From: Adam Cornish [REDACTED]
Sent: 24 November 2014 14:26
To: Neil Crowther
Cc: Tim Rainbird
Subject: BE/125/14/DOC

Please find below and attached, the response to the questions raised in consultation relating to BE/125/14/DOC (Condition 6: Construction Management Plan).

DRAWING TITLE:
Main Site Access & Logistical Management

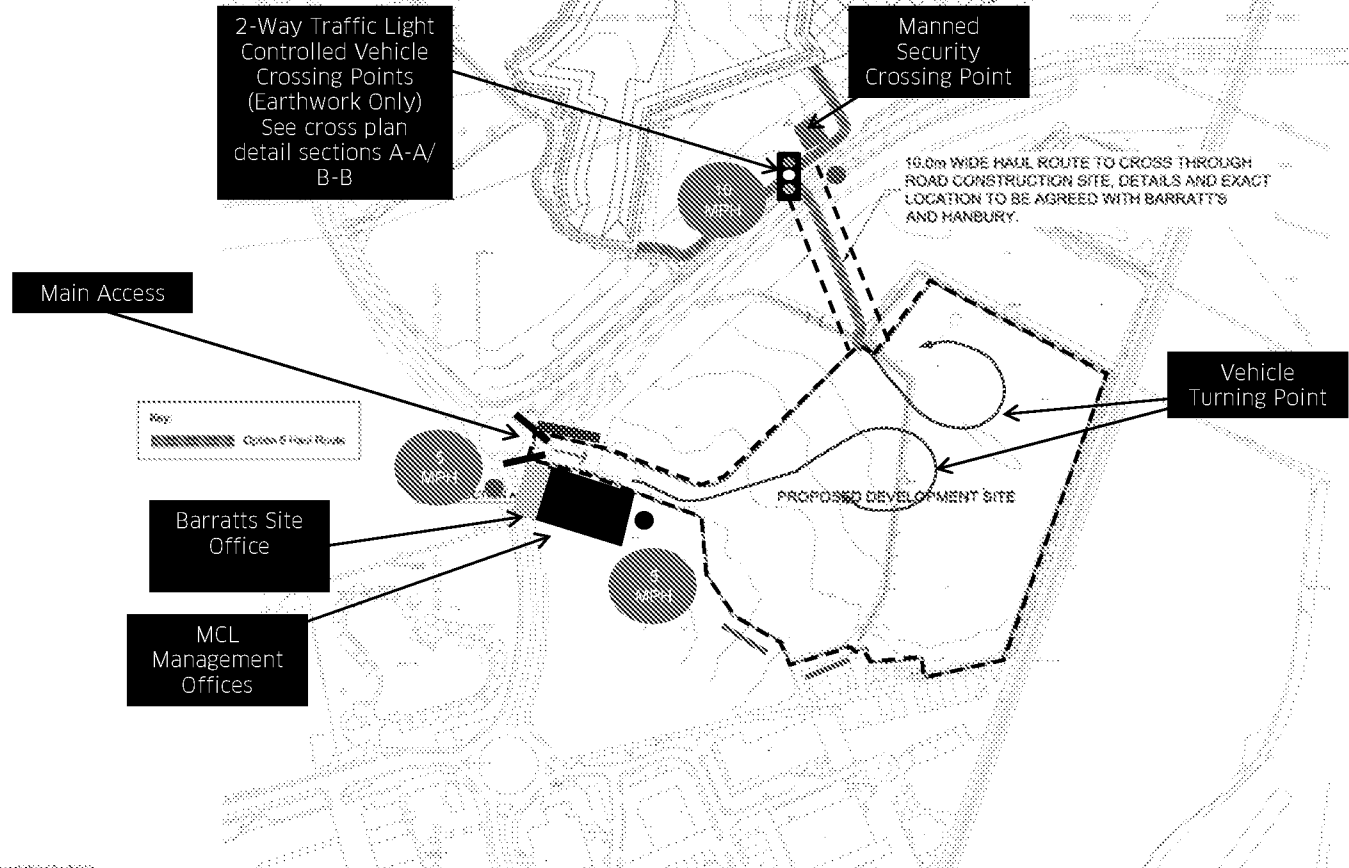
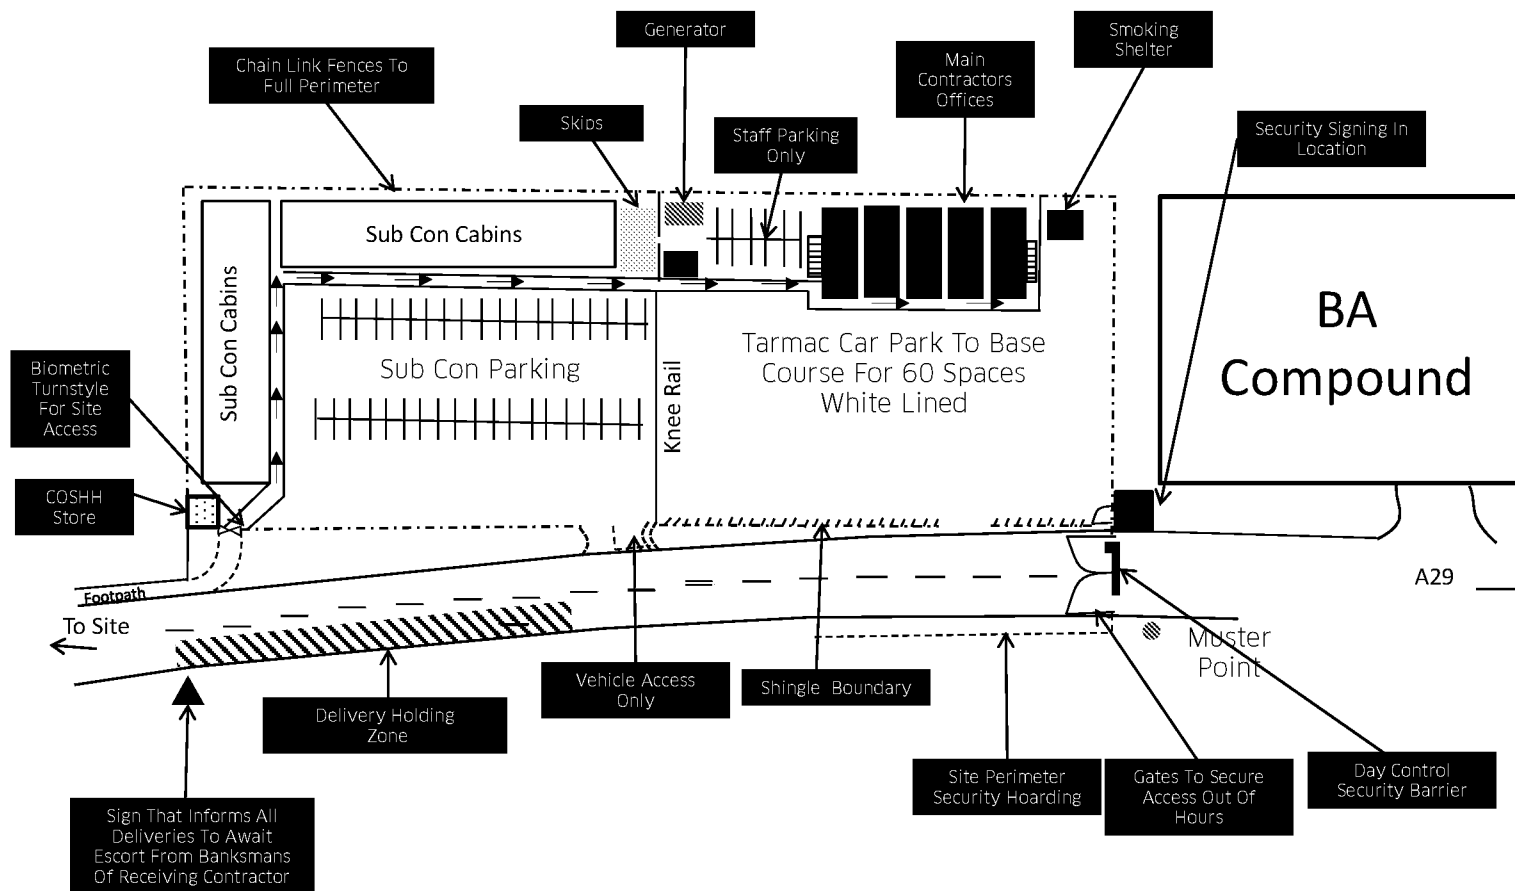
The site plan for access as issued was a site logistics plan used to demonstrate how the access is operated and more indicative of the operations rather than dimensionally accurate for exact position. The gate is actually 65m from the highway.

The gate is manned and open at all times to prevent lorries from backing onto the highway at any time.

A marked up plan. Not to scale but with dimensions inserted for reference.
